From: Jon Puplett [REDACTED]
Sent: 07 December 2021 12:21
To: Simon Davis
Subject: RE: P/159/21/PL 253-255 Inglenook Hotel Pagham Road Pagham PO21 3QB
Attachments: 2020-6289-006 Rev -.pdf; 2020-6289-001 Rev E.pdf

From: Simon Davis <Simon.Davis@arun.gov.uk>
Sent: 22 November 2021 18:37
To: Jon Puplett [REDACTED]
Subject: RE: P/159/21/PL 253-255 Inglenook Hotel Pagham Road Pagham PO21 3QB

Site Overview

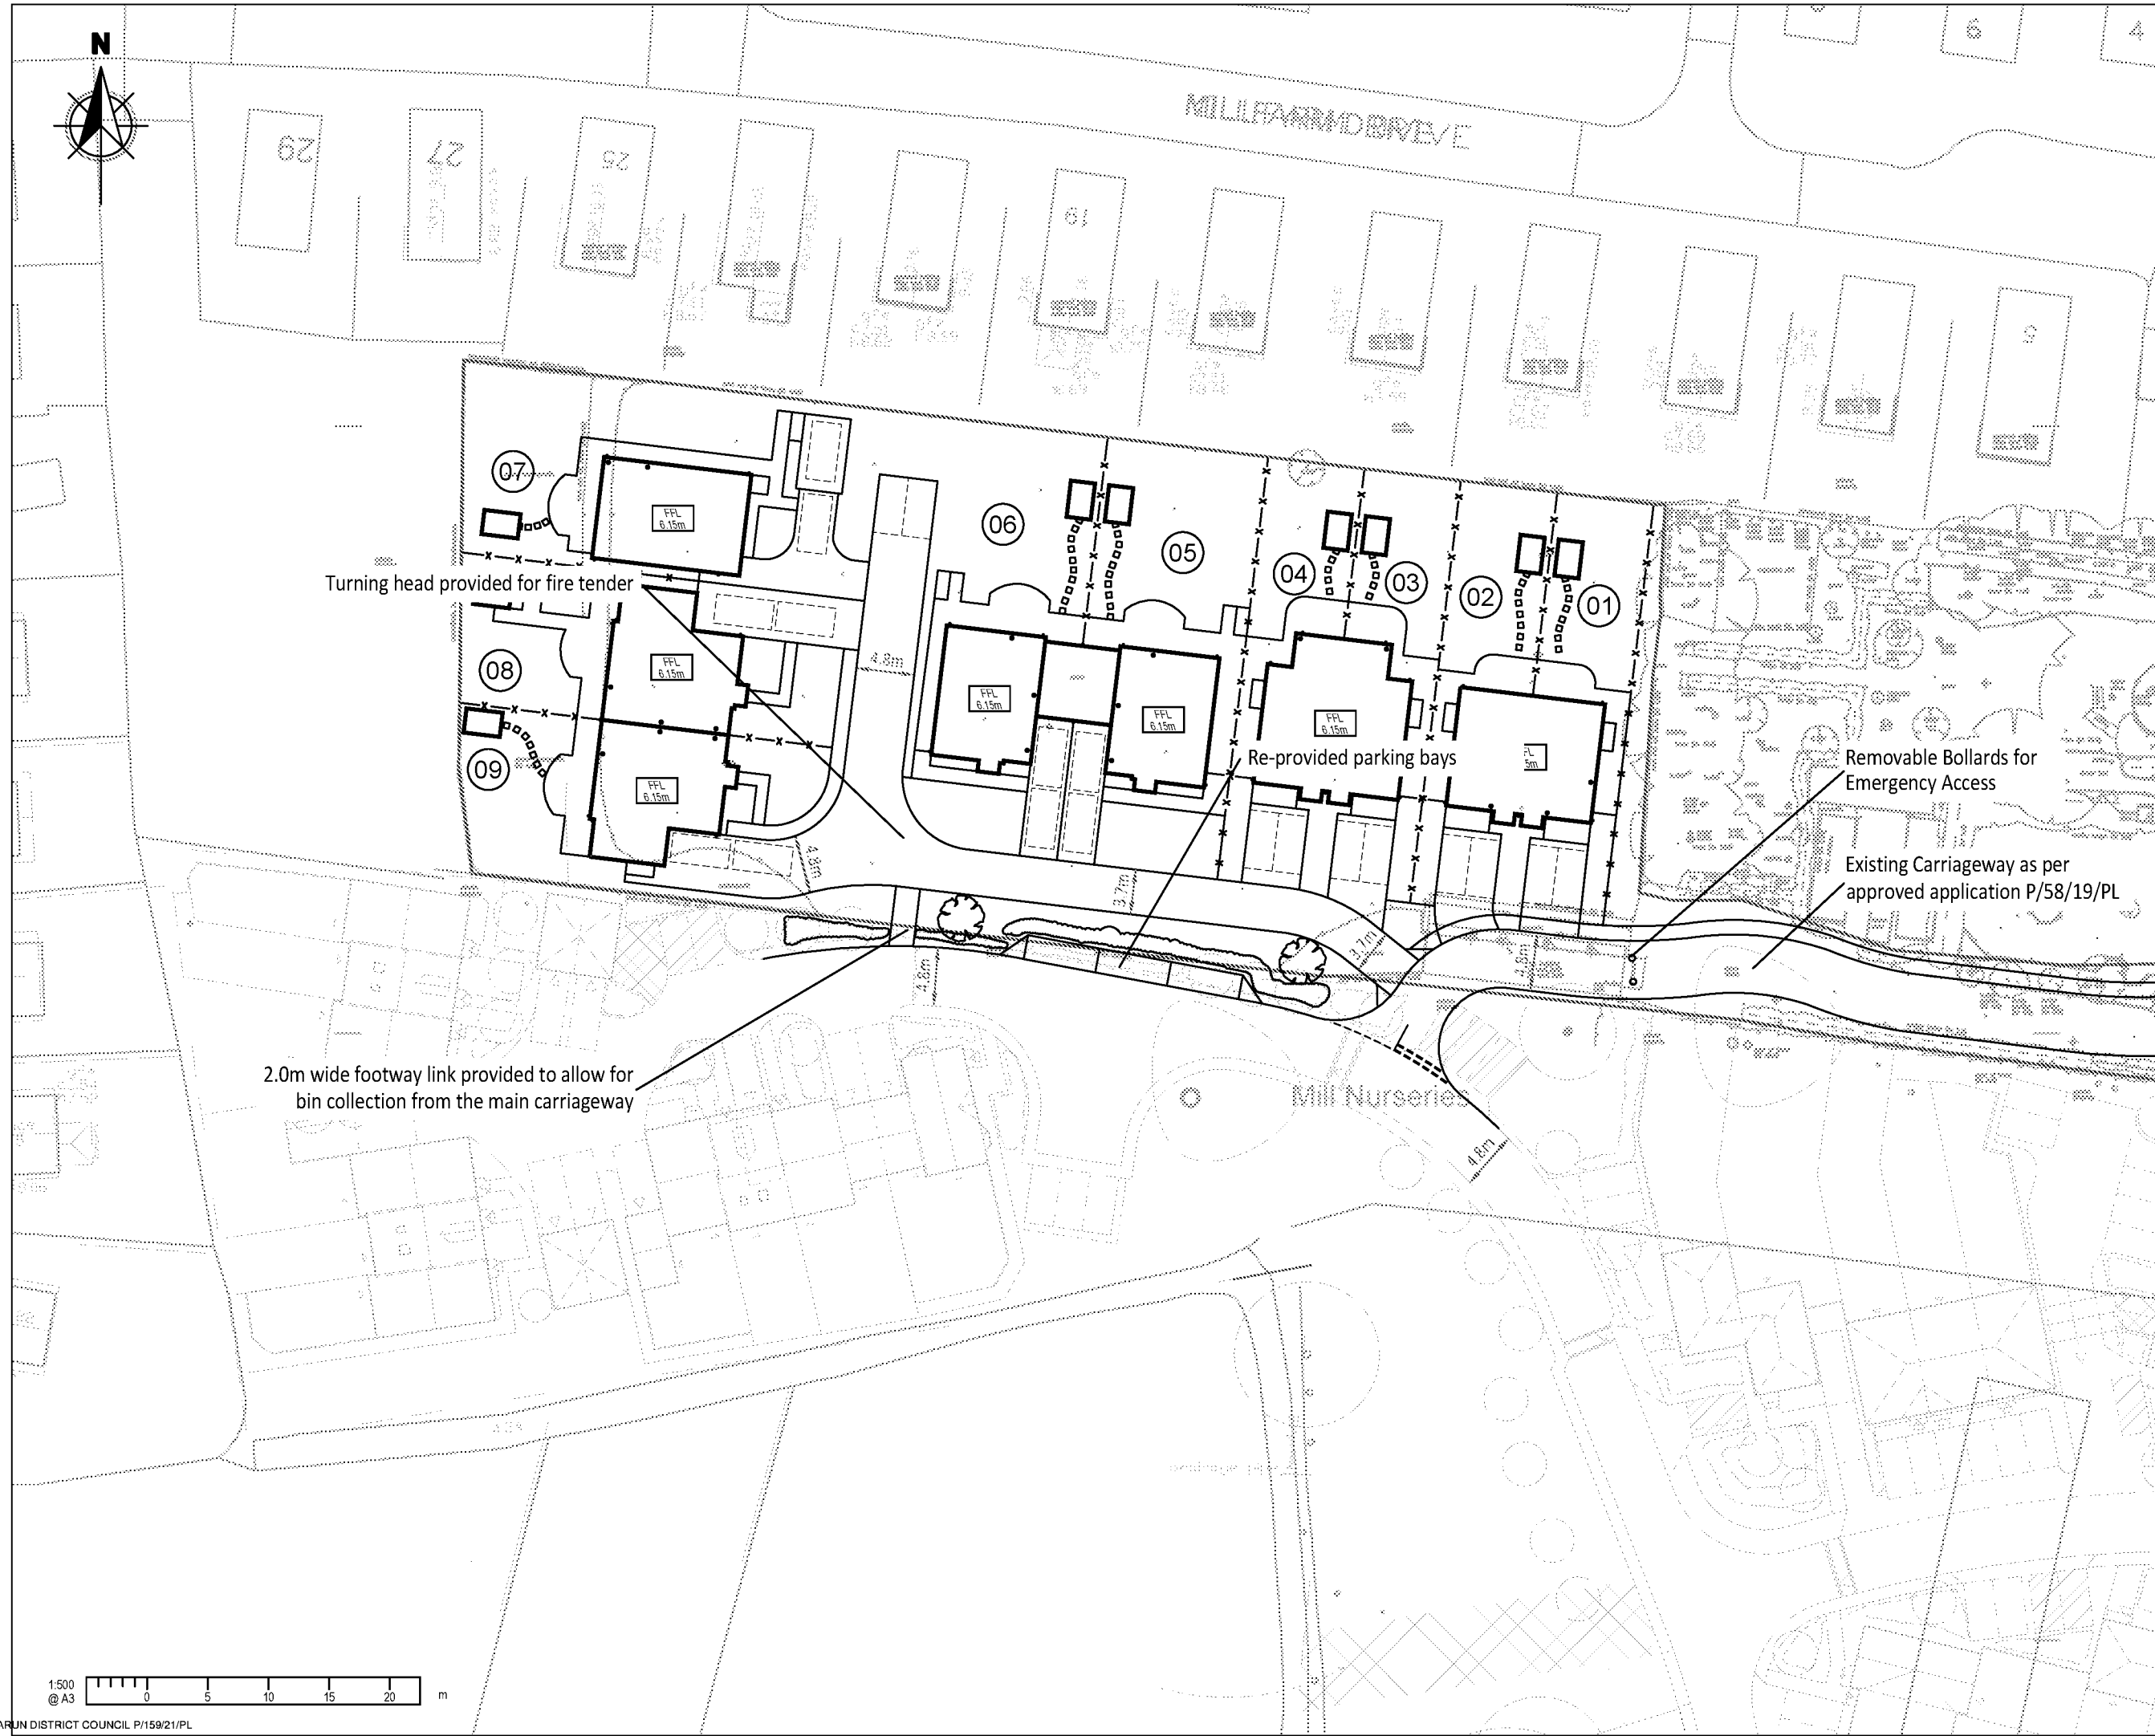
I was reviewing the parking arrangements earlier. Our requirements (as per the Arun Parking Standards SPD) are for 27 spaces (inc 2 visitor) and the proposal shows 19 spaces & 5 garages. As per the SPD, garages are treated as providing half a space if at least 3m by 6m. If this was the case, the provision would be 21.5 (shortfall of 5.5). However, your garages do not meet this so I can't count them at all. Therefore, the shortfall is 8 spaces.

I acknowledge that the development has already been approved, that it is not appropriate to reassess the whole scheme and that the previous decision was pre the adoption of the Arun Parking Standards SPD. However, the addition of the 4th bedroom to plots 5, 6, 8, 9 adds a requirement for 1 extra space to each of these dwellings (so 4 in total) and so I have to therefore assess the extra requirements. You could

resolve this be either removing the 2nd floor accommodation from the scheme, replacing the garages to these plots with car ports or finding 4 spaces elsewhere in the layout.

Please find revised drawings attached which show the 4x additional parking spaces requested. Plots 5, 6, 8, 9 now all have garages plus 3x outdoor parking spaces.
